Dubbo Hospital Stage 4 Redevelopment

Response to Submissions – SSD 16_7720

SCALE
A3
0 5 10 1:500
CAD FILE NO.
16S1359100-08-P2.dgn

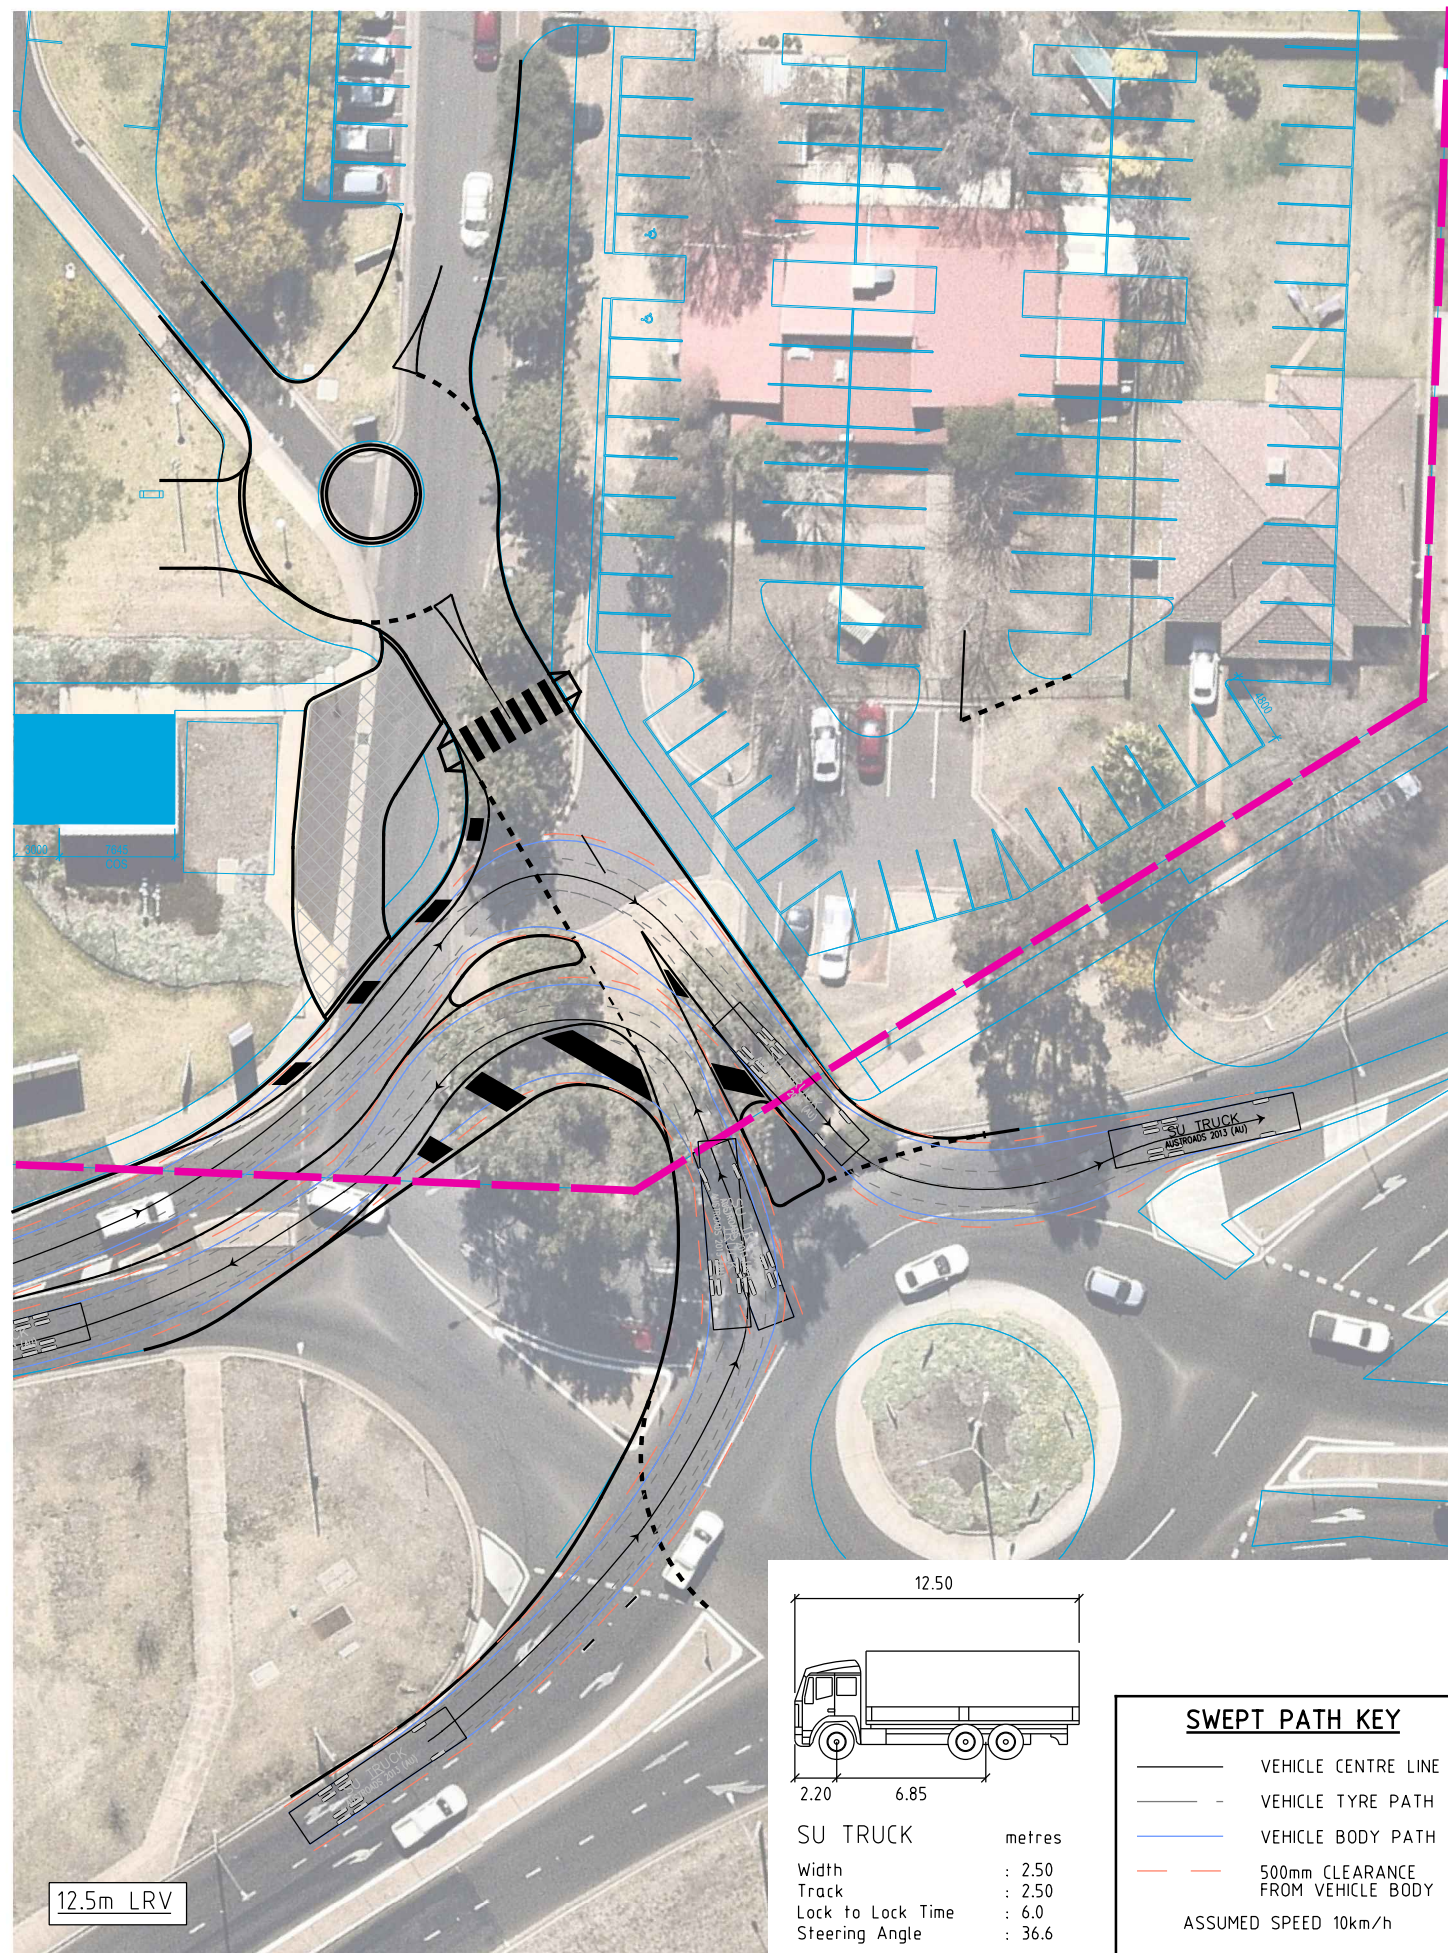
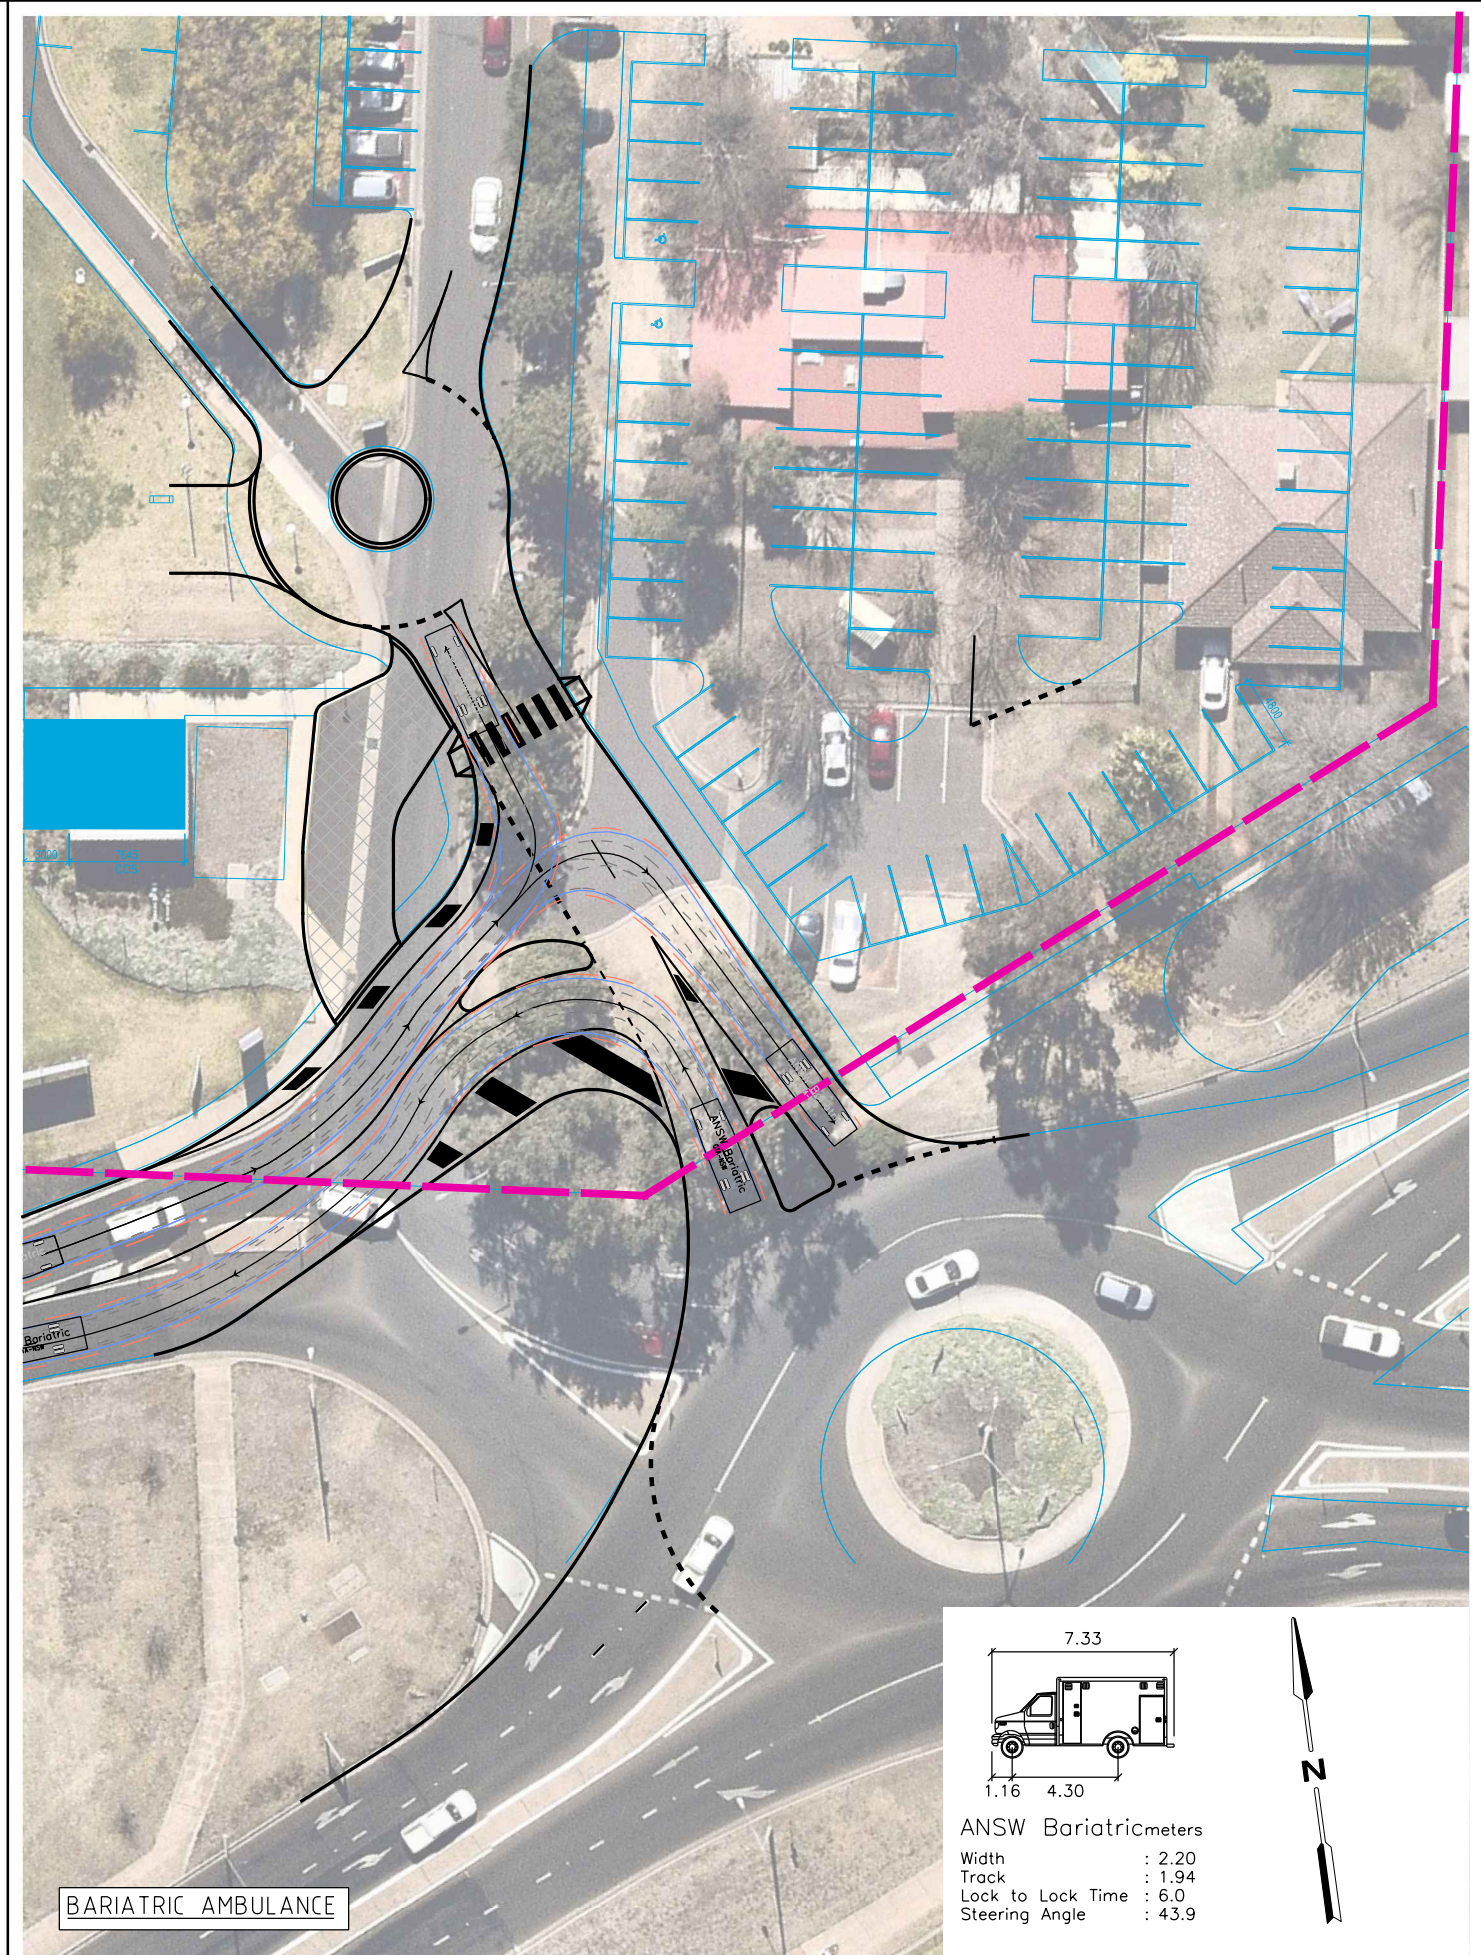
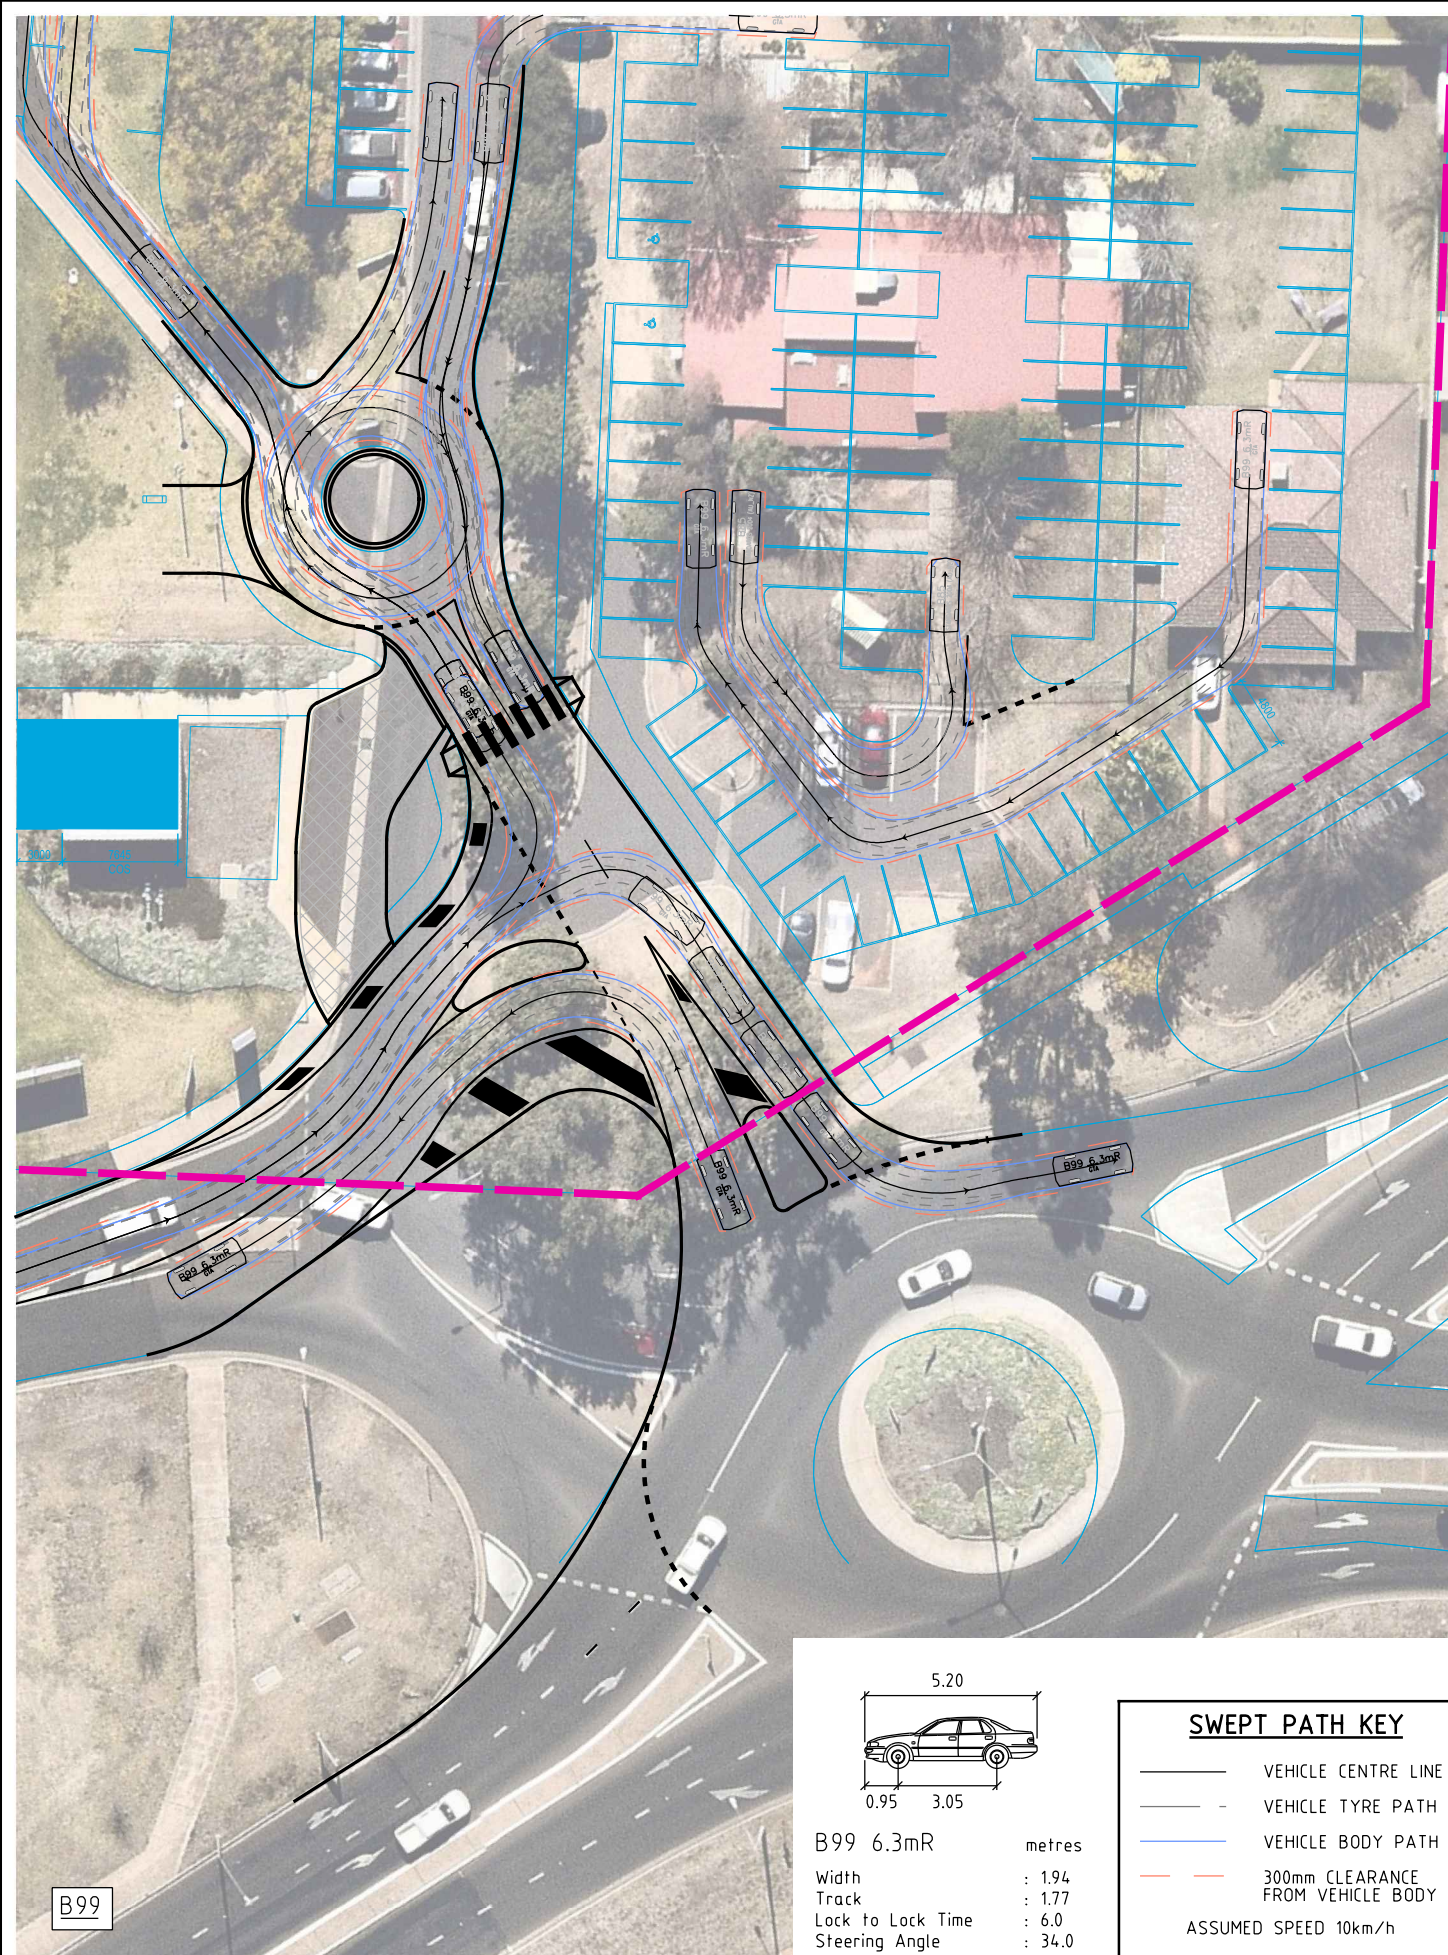
There are significant concerns which were initially flagged with the geometric realignment of Myall Street into the hospital property and intersection with Cobbora Road, and the potential traffic conflict in this locality, that have not been addressed to the satisfaction of Council. Council is disappointed that there has not been ongoing consultation on the transportation strategy and the potential opportunities available to enhance the long term accessibility needs for the Dubbo Base Hospital and the community.	
Further concerns are raised regarding the proposed Myall Street realignment and associated intersection arrangement with McGuinn Drive and to a lesser extent the new access onto the Cobbora Road roundabout in that it may not provide the optimum outcome. It is noted that it would be some time before the transportation improvements would be implemented. As such, a holistic approach should be undertaken of the Dubbo Base Hospital redevelopment, with consideration of all the mitigating factors including:

4. The proposed traffic management comprising of the Myall Street realignment, McGuinn Drive intersection and new Cobbora Road access and transition appears to promote an environment for traffic and pedestrian conflict with constrained turning paths, short travel distances for driver interpretation and decision making, no vehicle separation into Myall Street.	Refer to comments above. In response to the submissions received, and following further consultation with Council and RMS, the access arrangements off Myall Street and the Cobbora Road roundabout have been amended. As noted above, the revised layout offers a number of benefits compared to the existing access arrangements. In response to this particular concern, the identified issue of short travel distances within the hospital for driver interpretation and decision making is removed, with appropriate advanced warning and directional signage, as well as hospital identification signage, able to be provided on the adjacent road network to guide any unfamiliar users into the hospital. This would reduce the risk of vehicle conflicts.

3. The proposed re-alignment of Myall Street being a public road into Dubbo Base Hospital property. Property adjustment required.	As noted above, the revised layout removes any impact (by the Myall Street alignment) on property boundaries.
